**Application: SSI 7485**

I am writing to you regarding the proposed modifications to the M4-M5 link, Mod 2 The Crescent overpass and changes to pedestrian infrastructure in North Annandale, Rozelle and Rozelle Bay Foreshore Area.

## Introduction

Figure 4-2 Pedestrian and cyclist bridge infrastructure options

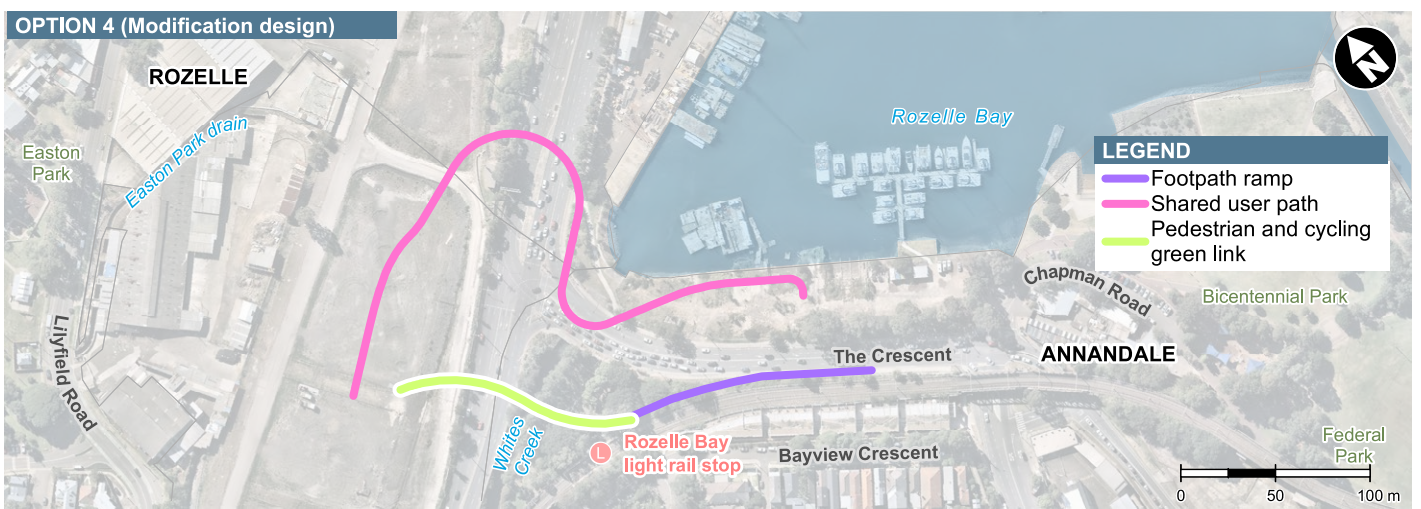
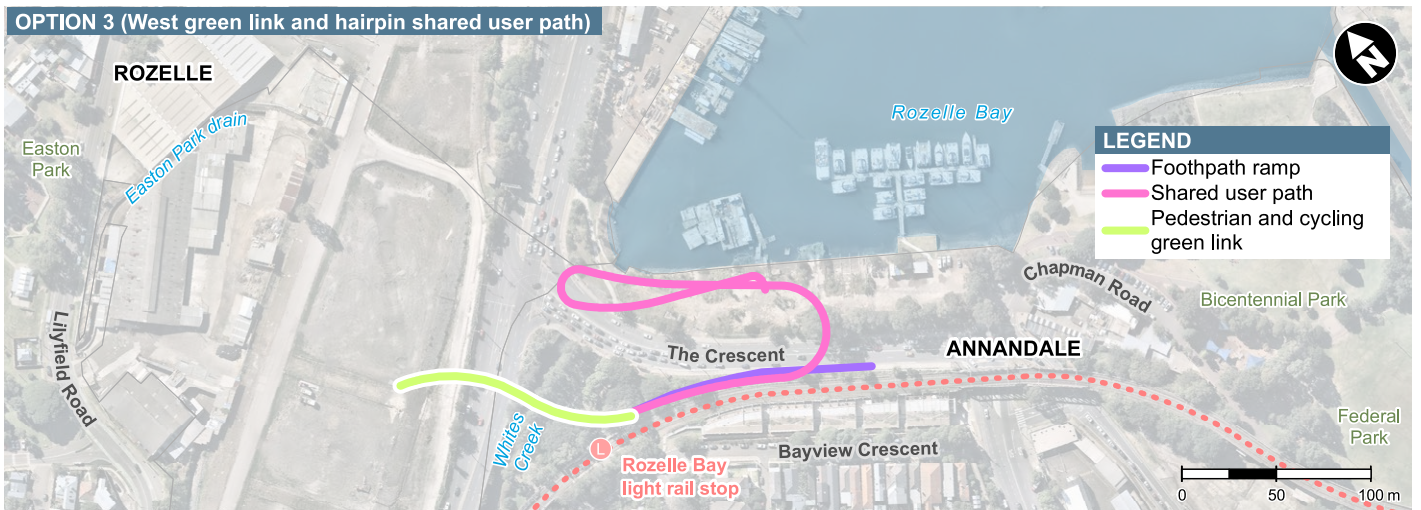
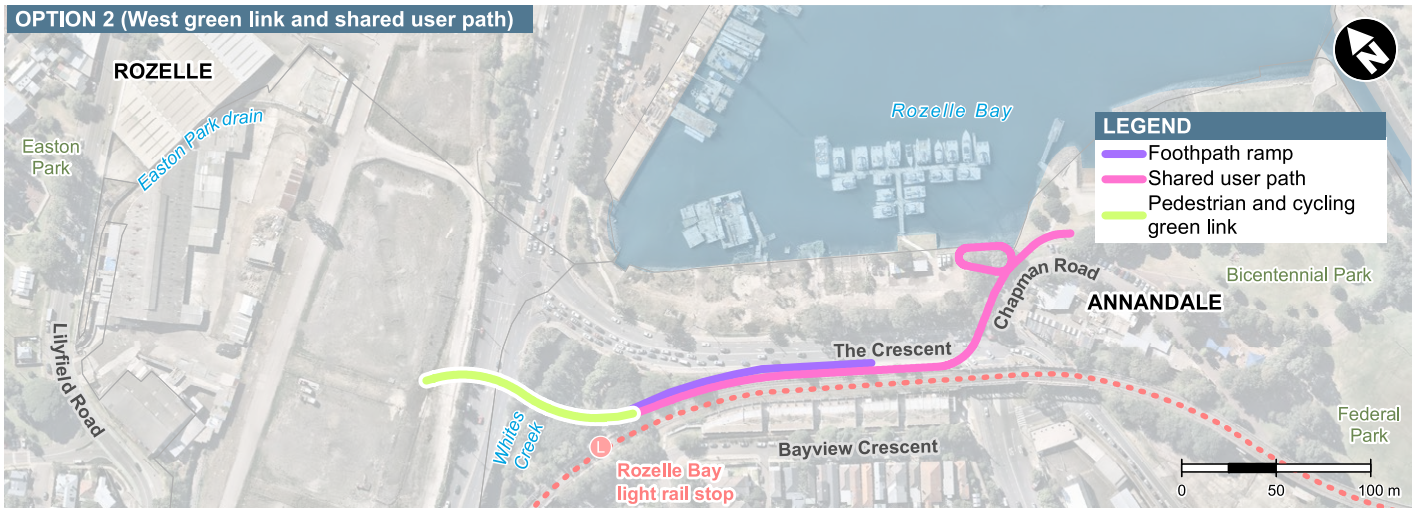
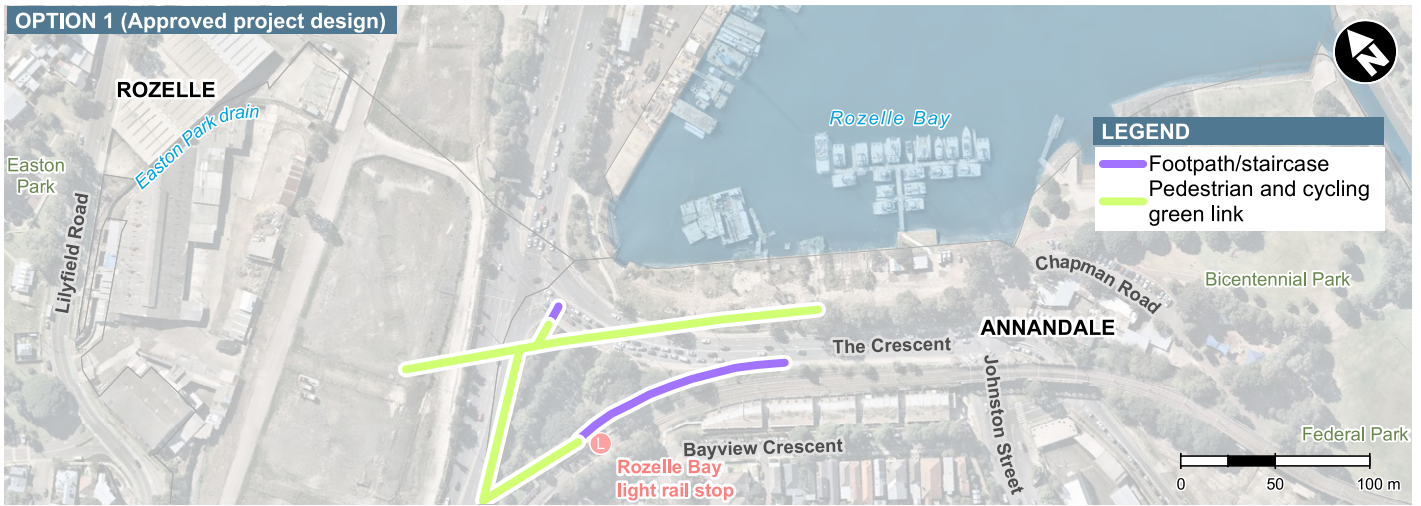
The mod2 design requires the green link to move west of the Crescent. This means that:

- cycle and pedestrian traffic will now:
  - o Need to cross on the south side of the Crescent, which is currently very narrow, and traverse the 4 intersections – outlined above.

- Not have direct access to/from the Glebe foreshore and the new parks in Rozelle
- The green link's view over the bay will be completely blocked by the concrete overpass

This is a monumental design failure.

Figure 4-3 The Crescent, Johnston Street, Chapman Road intersection options

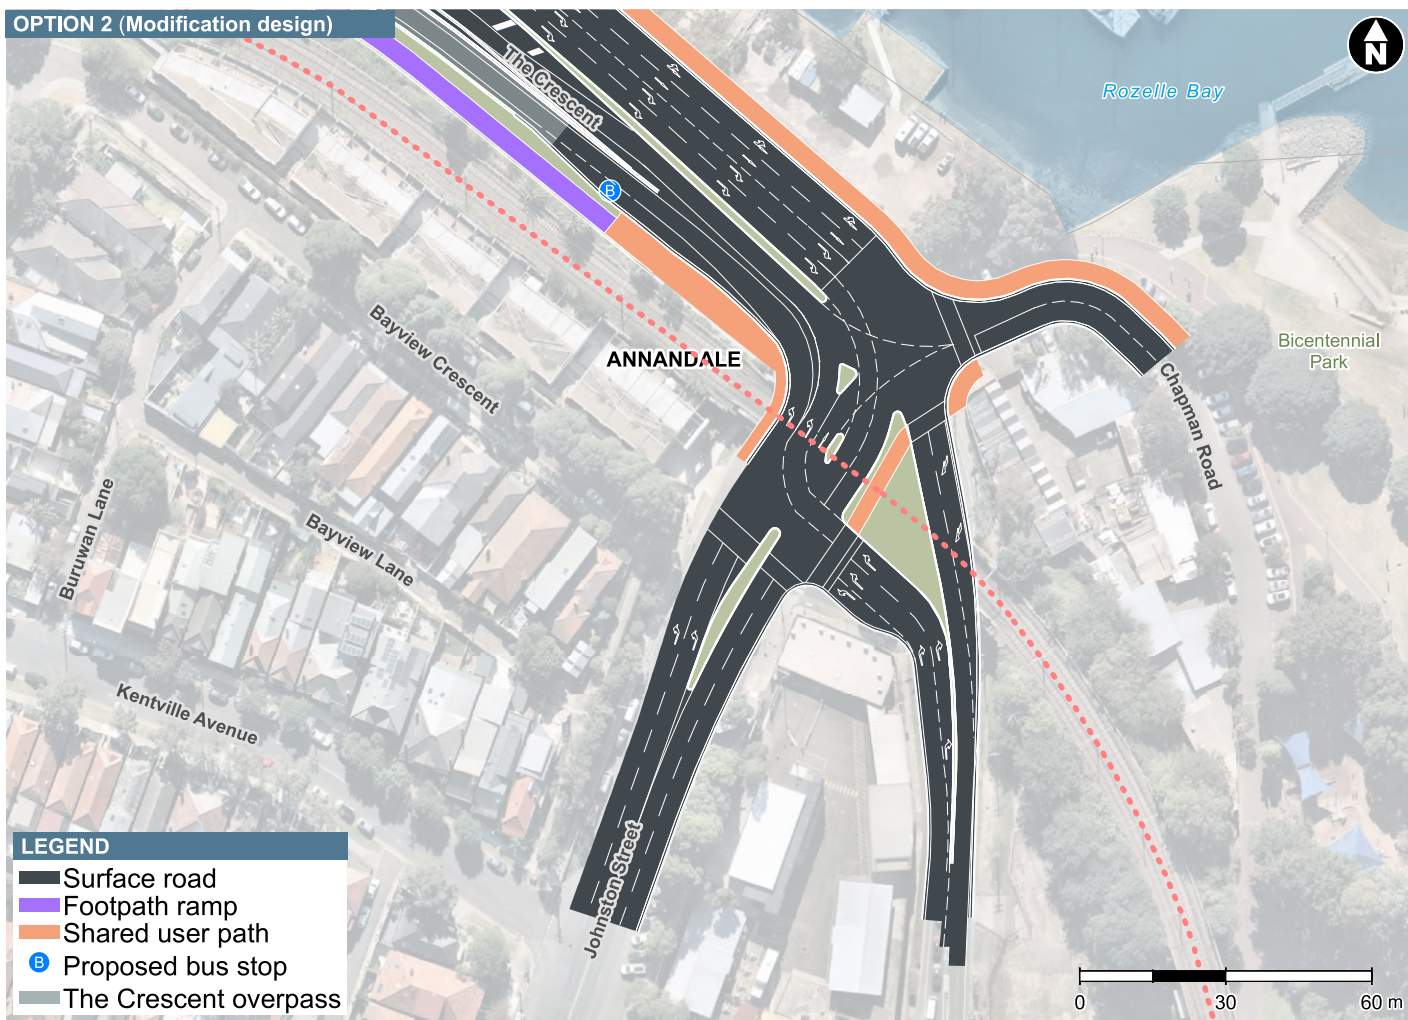
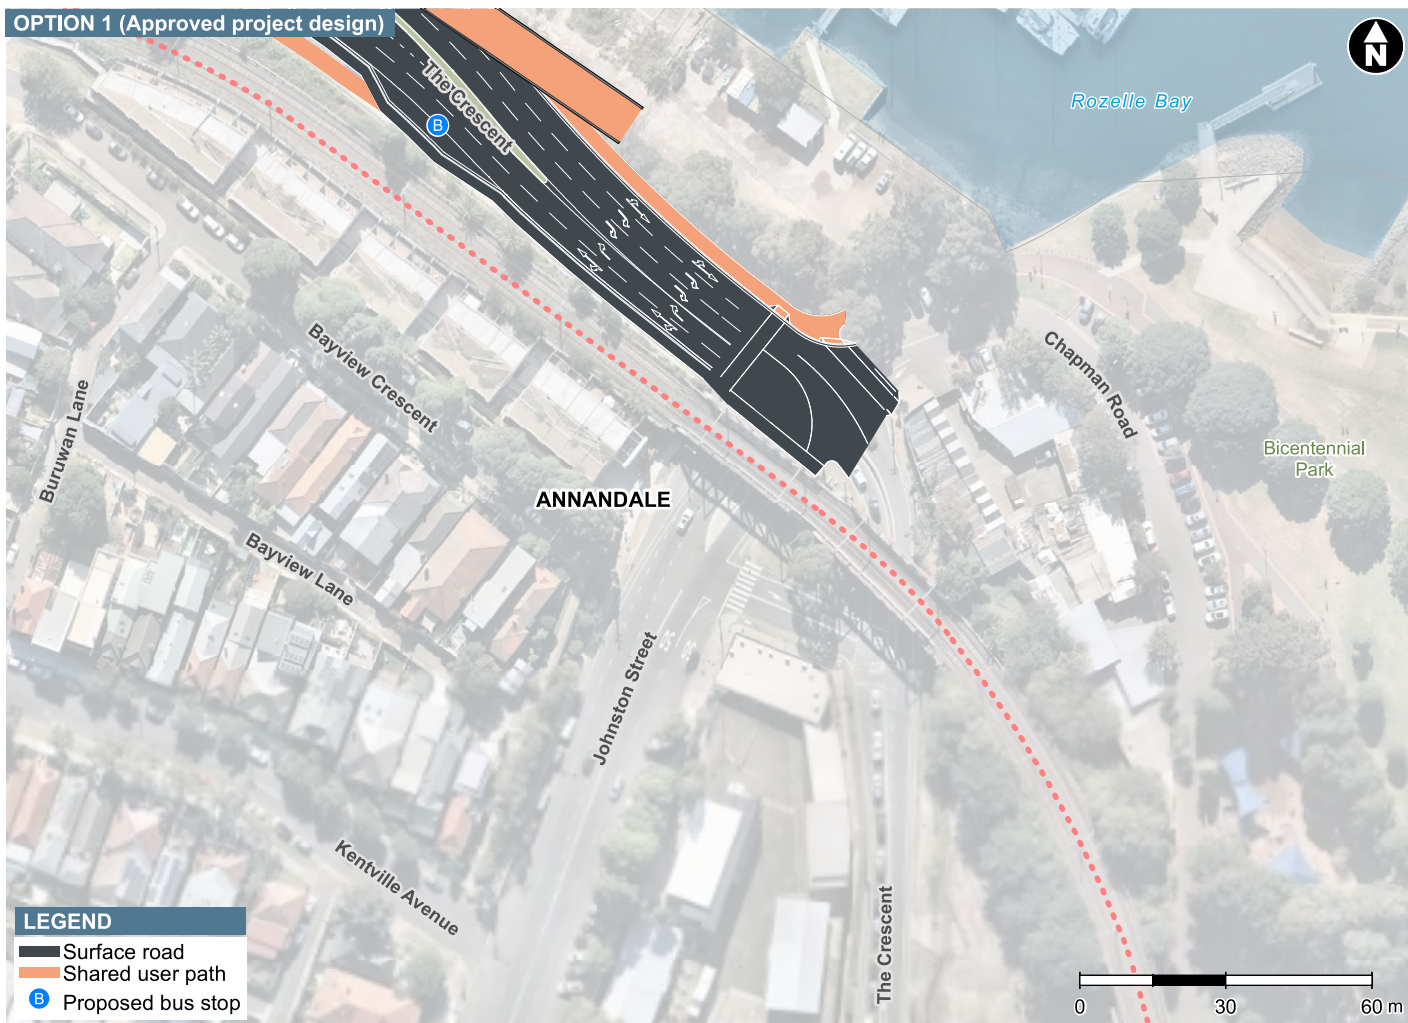
As part of the Mod2 changes, the intersection at the Crescent and Johnston St will be changed. As part of these changes, traffic will **no longer be able to turn right into the Crescent from Johnston St.**

Mod2 changes to the intersection at Johnston St and the Crescent will require pedestrians and cycle traffic from the North side of Johnston St **to cross 4 intersections** rather than the **current 1 intersection** – increasing the chance of injury or fatalities at this intersection.

- The Crescent east of the bridge at Johnston St is only a single carriage way.
  - o East bound traffic will need to navigate the blind corner under the bridge and immediately merge into a single lane - increasing the likelihood of accidents
  - o West bound traffic, steps up from a single lane into a dual lane holding bay, waiting for a green single. The holding bay in the area between the Crescent and Johnston St, allows for an additional 4 cars compared to the current flow. However, upon a green light traffic will now need to:
    - Give way to pedestrian traffic crossing Johnston St, thereby holding up left turning traffic and blocking/reducing the flow out of the holding bay
    - Navigate “the slow squiggle”, marked in red, which requires a minimum of two turns and adds 42 meters and reduces the flow and number of North bound vehicles which can be cleared from the Crescent.

North bound traffic on The Crescent is already a problem in the afternoon. This design will further exacerbate the problem.

Figure 4-4 Elevation: Indicative view of The Crescent overpass

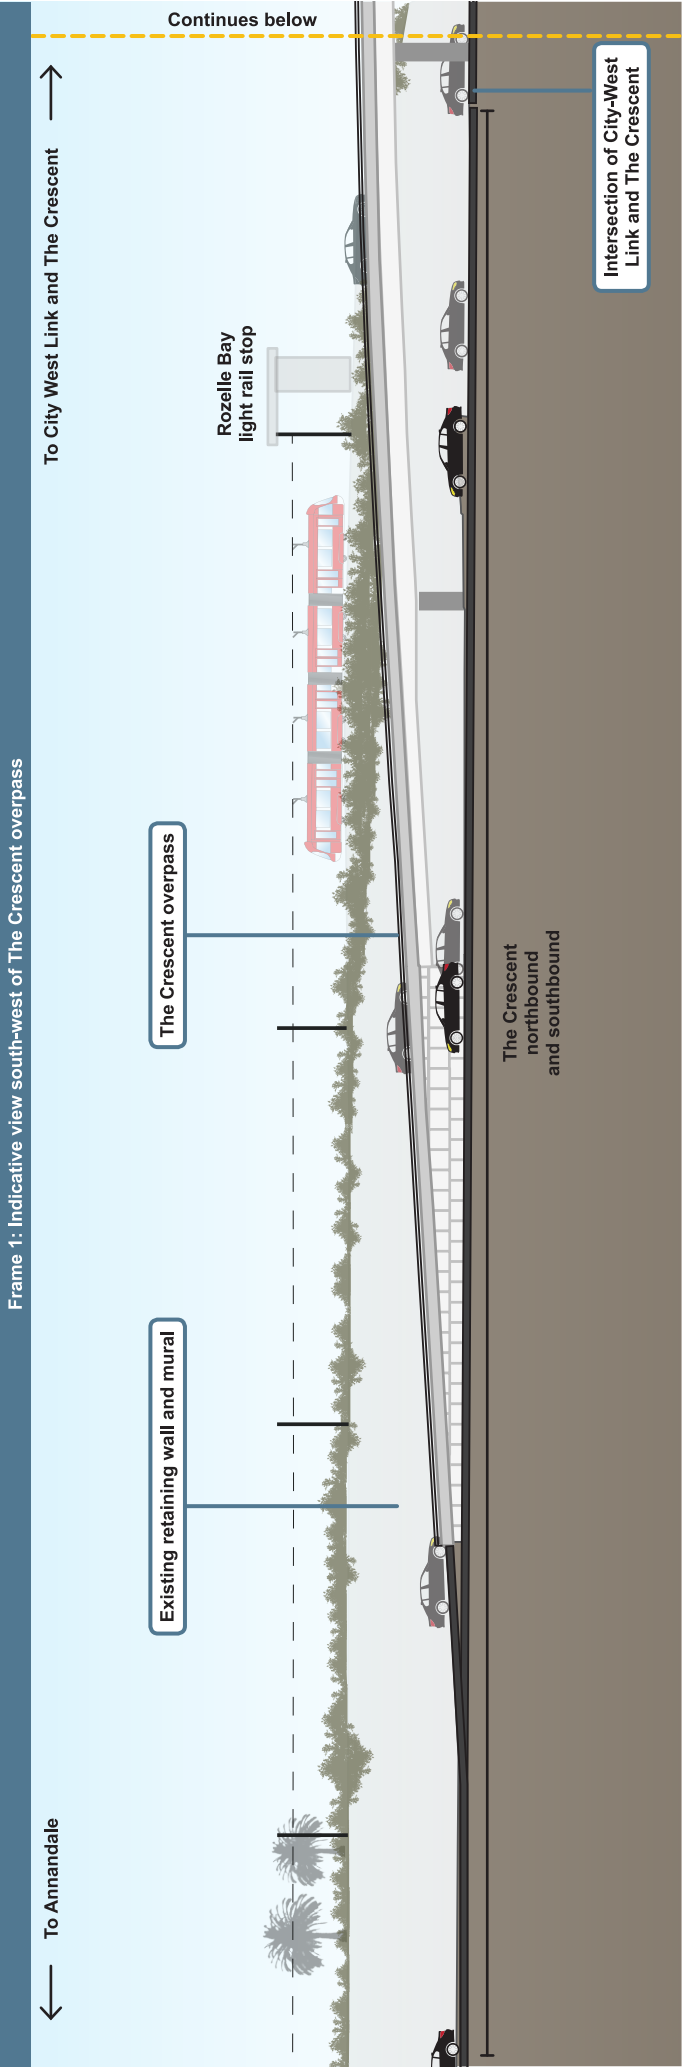
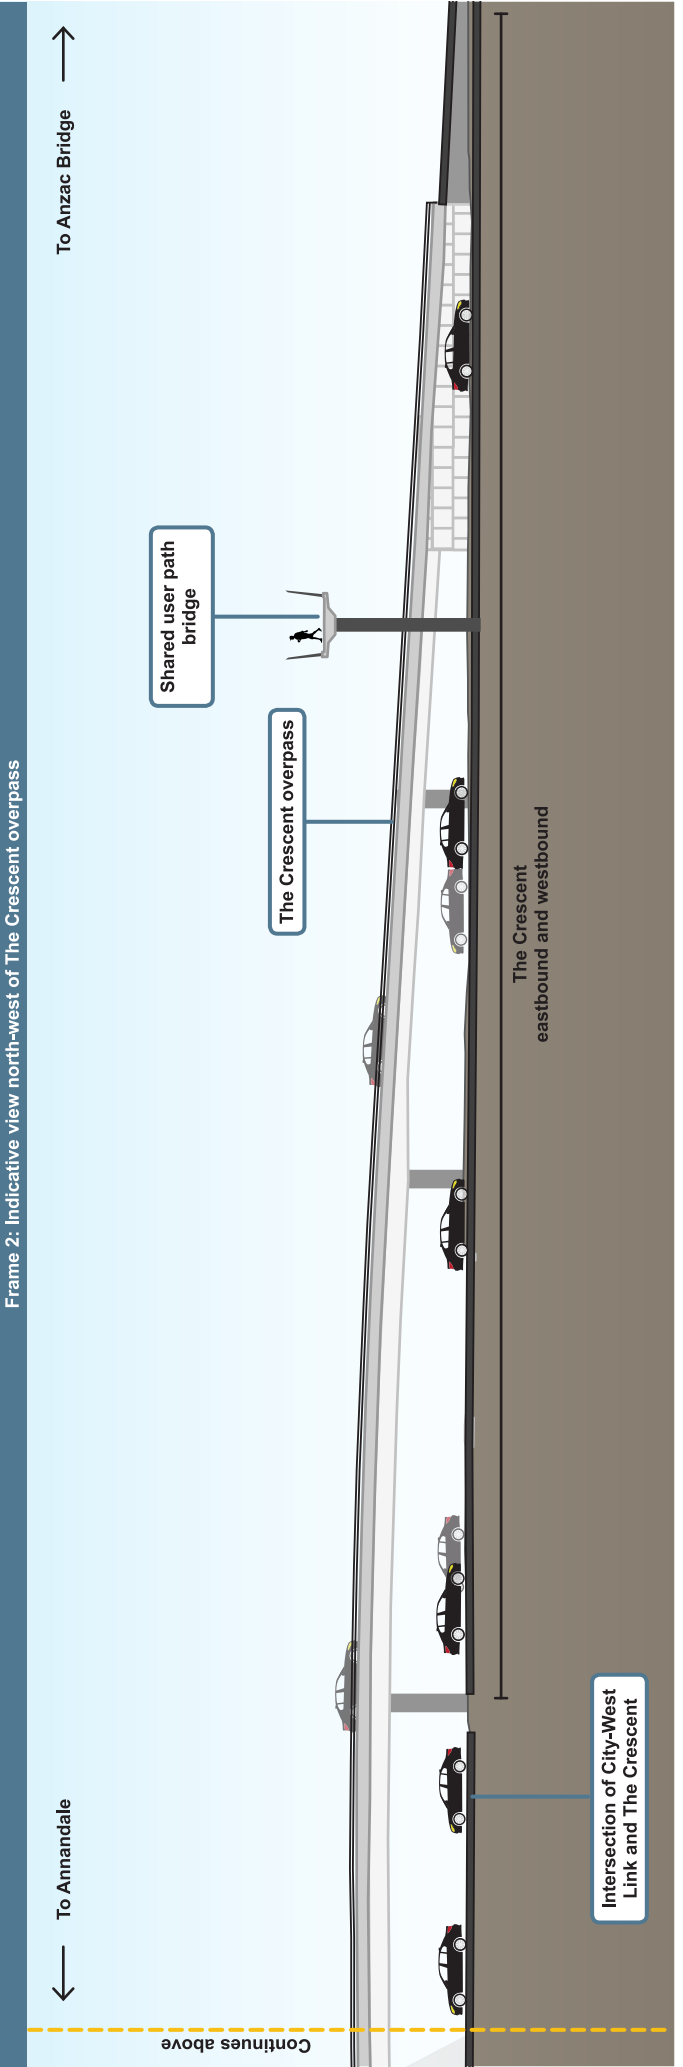
*View from the Greenway of the Bay completely blocked by overpass*
